PROJECT NO. PR-2021-006070
Application No. SI-2021-01888

Re: Westpointe40 South Site Plan DRB Comment Responses (PR-2021-006070)

This memo outlines the responses and changes made to the site plan for the proposed 60K warehousing and distribution building at Westpointe40 based on the comments received and reviewed at the December 15, 2021 DRB meeting.

BLUE SKY DISTRIBUTING ALBUQUERQUE, NM	DRAWN BY pm DATE 11-4-21
	SITE PLAN FOR BUILDING PERMIT	DRAWING 2020088-60K.DWG
	5571 MIDWAY PARK PL NE ALBUQUERQUE, NEW MEXICO 87109 (505) 858-3100 www.tierrawestllc.com	SHEET # SP-1 JOB # 2020088

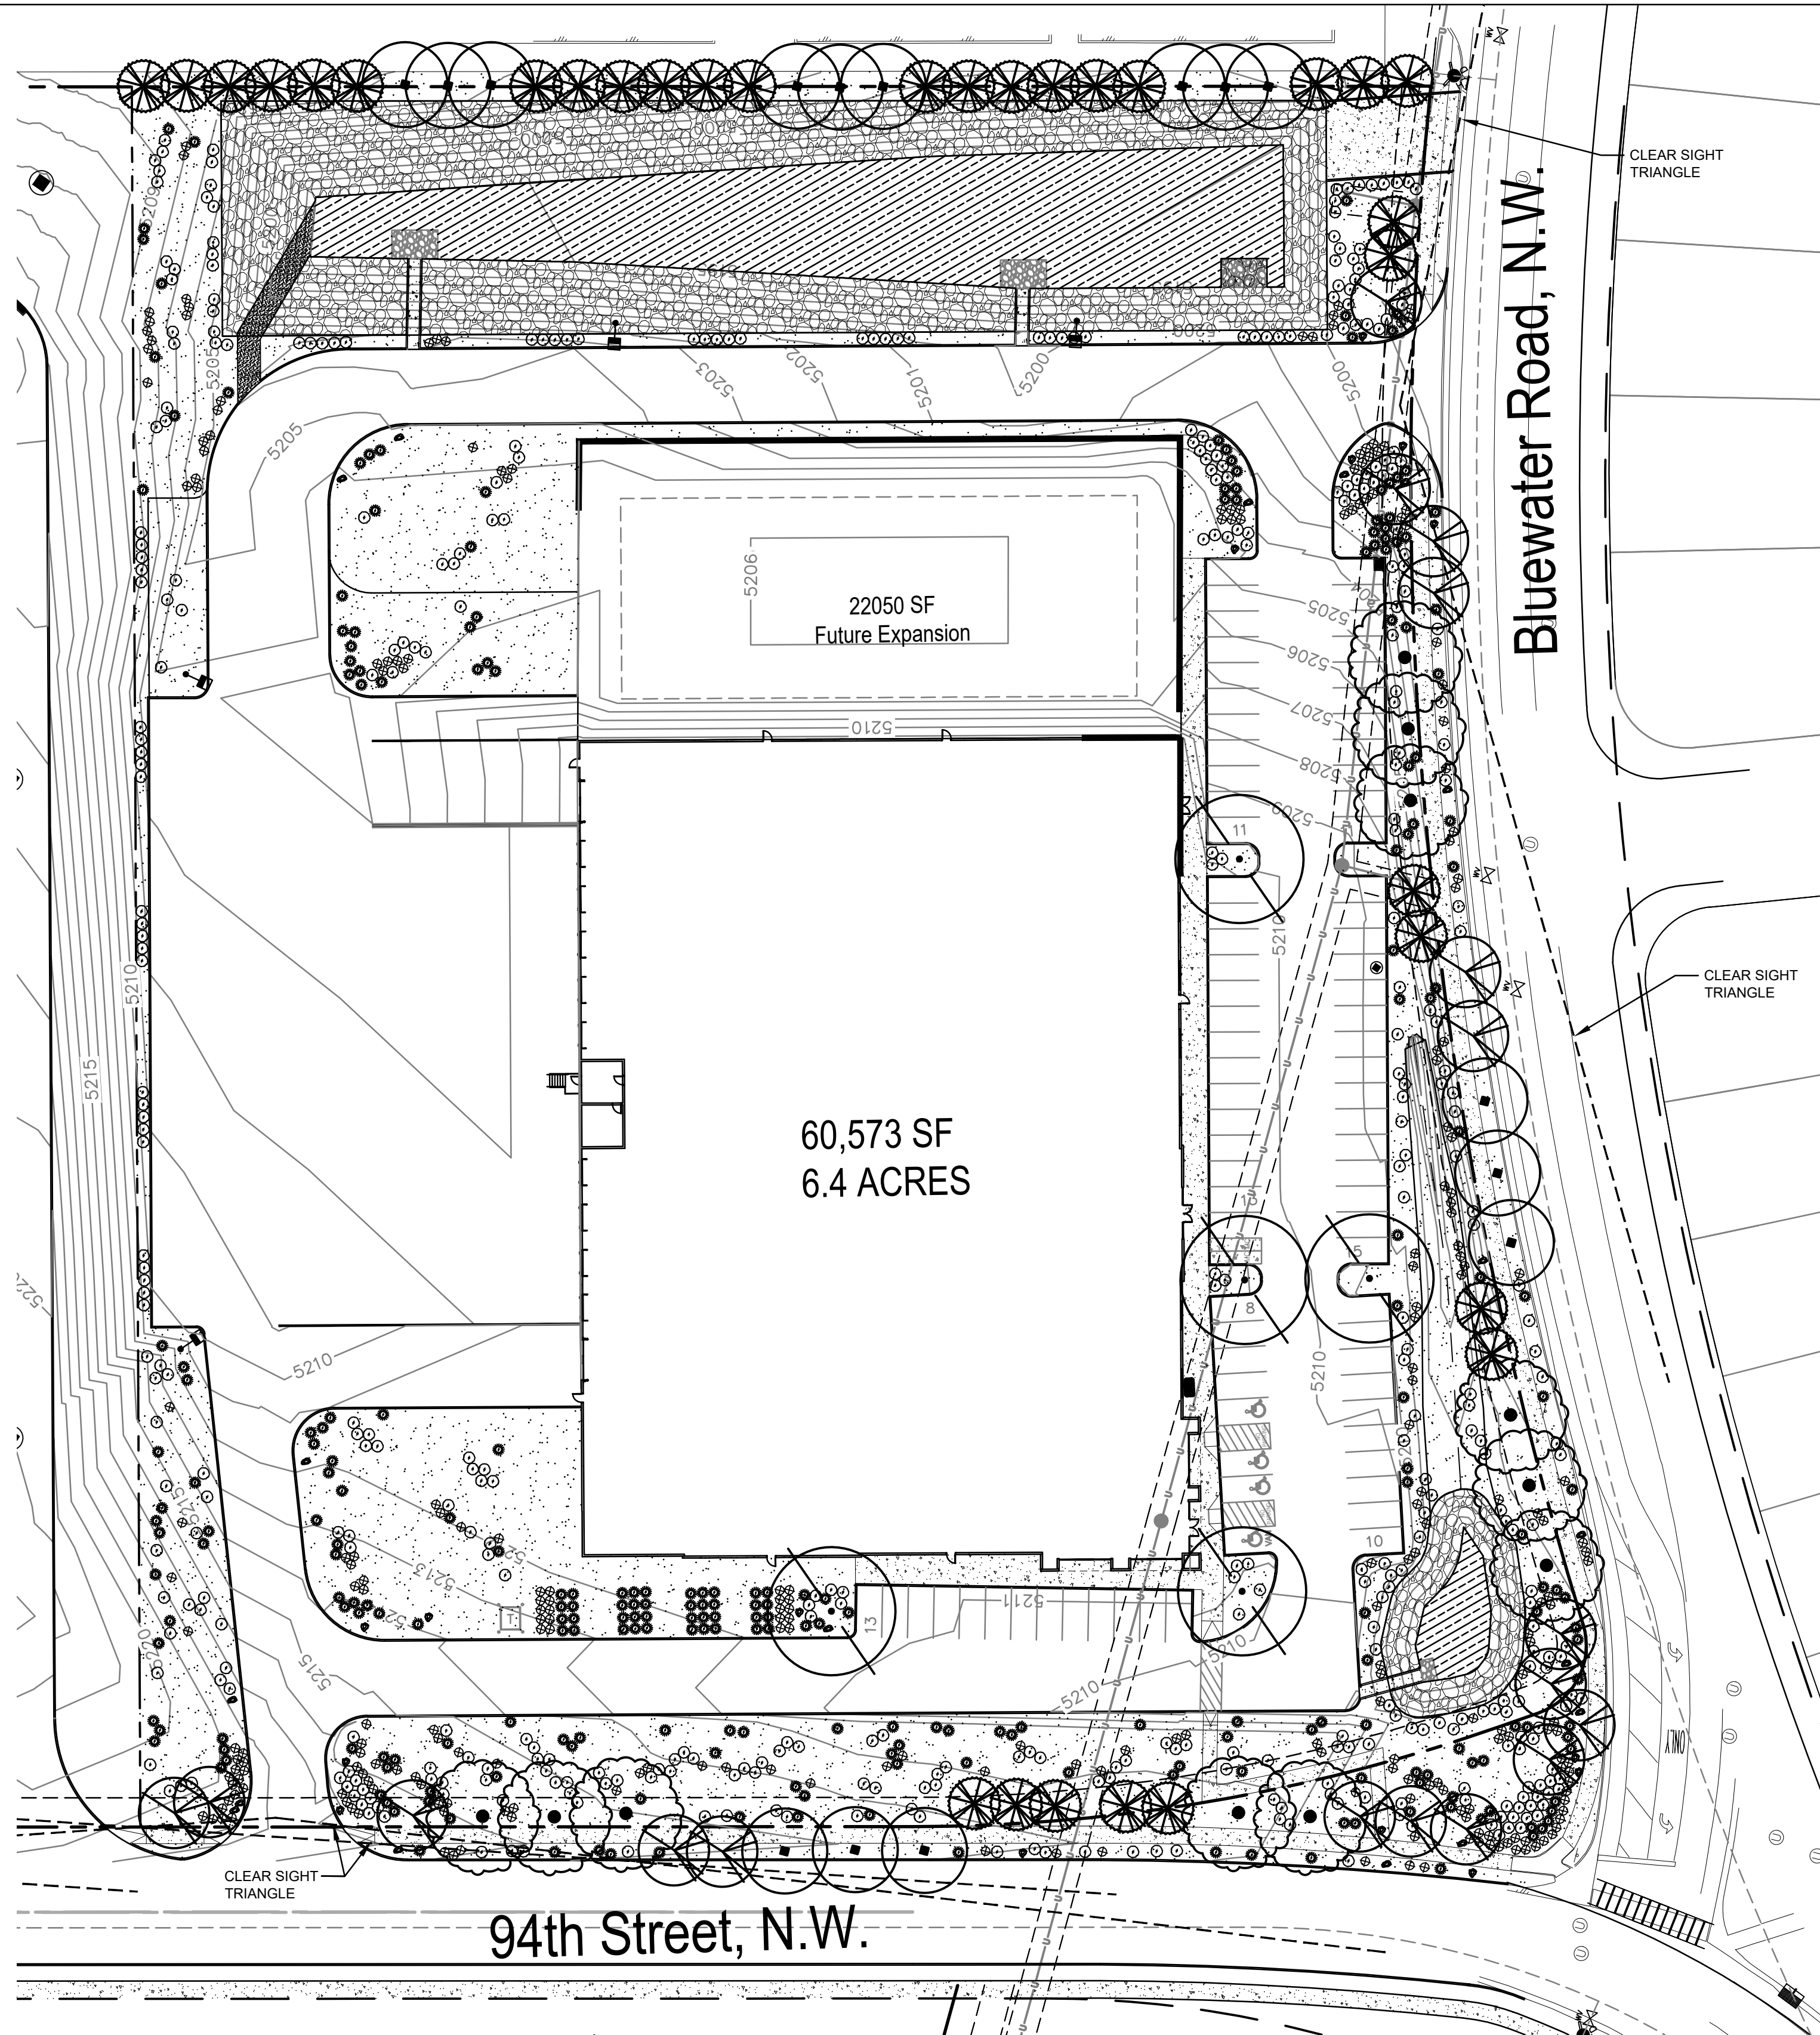
1. Based on the turning template provided, there is minor overlap between truck turning movements and the curb. Radii appear to need adjustment at the 90-degree bends, and it appears that the entrance off of Bluewater shall need to be modified to accommodate the turning movements.

- *The radii have been adjusted slightly on the Site Plan and updated turning template exhibits are provided.*
2. On the cross-section shown, the minimum width for a bike lane is 5 feet without the curb, and the minimum required vehicular lane width is 11 feet. Make any adjustments as needed.
